Addendum No. 1

RE: Contract ID: C201719
WBS# 5CR.10321.7
Durham County
NC-54 From Falconbridge
Road To Dresden Drive.

February 20, 2007 Letting

## SUMMARY OF QUANTITIES

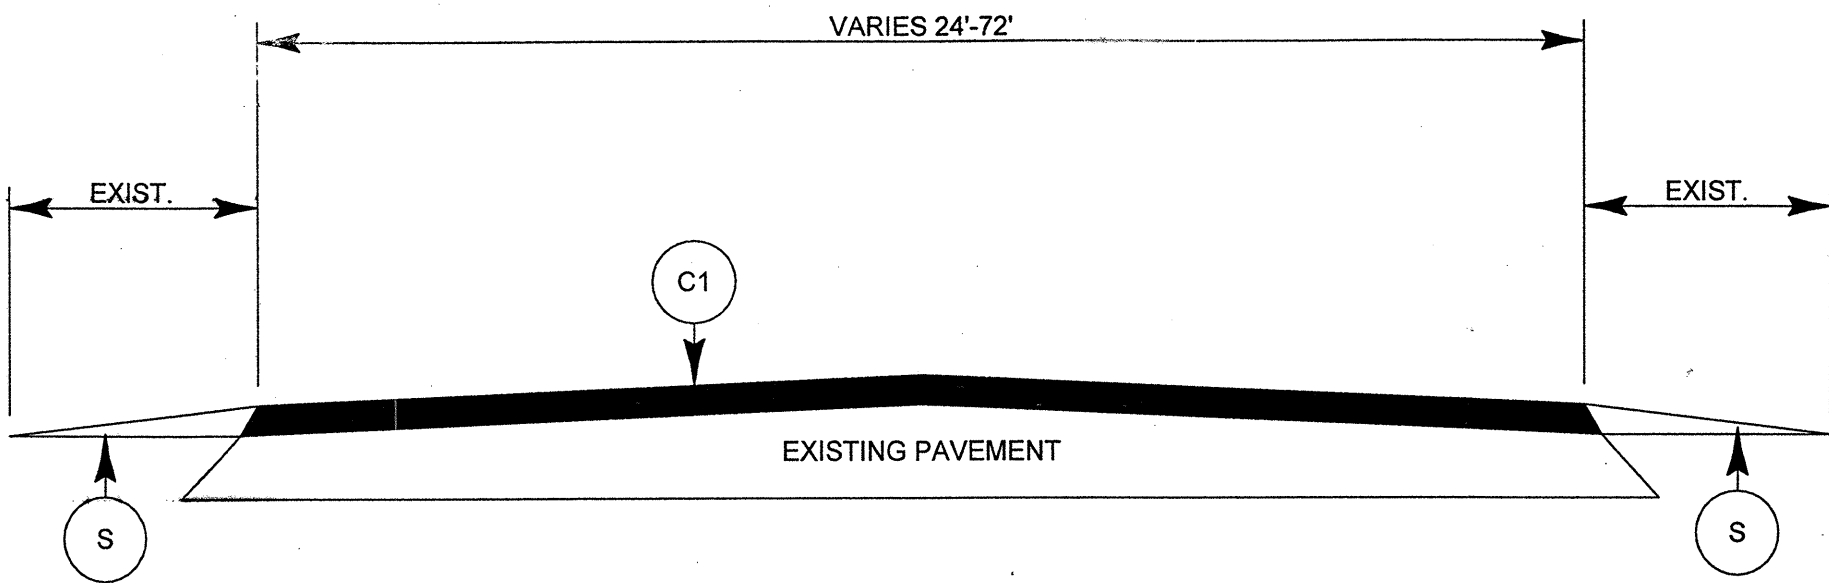
On Sheet No. 2, the Summary of Quantities has been revised to reflect the above noted changes. Please void Sheet No. 2 in your sketch maps and replace with the revised Sheet No. 2.

On Page No. 1 and New Page No. 2 of the Item Sheets, two new pay items have been added: By copy of this addendum the following new line items are hereby added: "17-2830000000-N-858 Adjustment of Manholes" Quantity = 2 EA and "18-2845000000-N-858 Adjustment of Meter Boxes or Value Boxes" Quantity = 3EA. The Contractor's bid price shall include the new pay items. The Contract will be prepared accordingly.
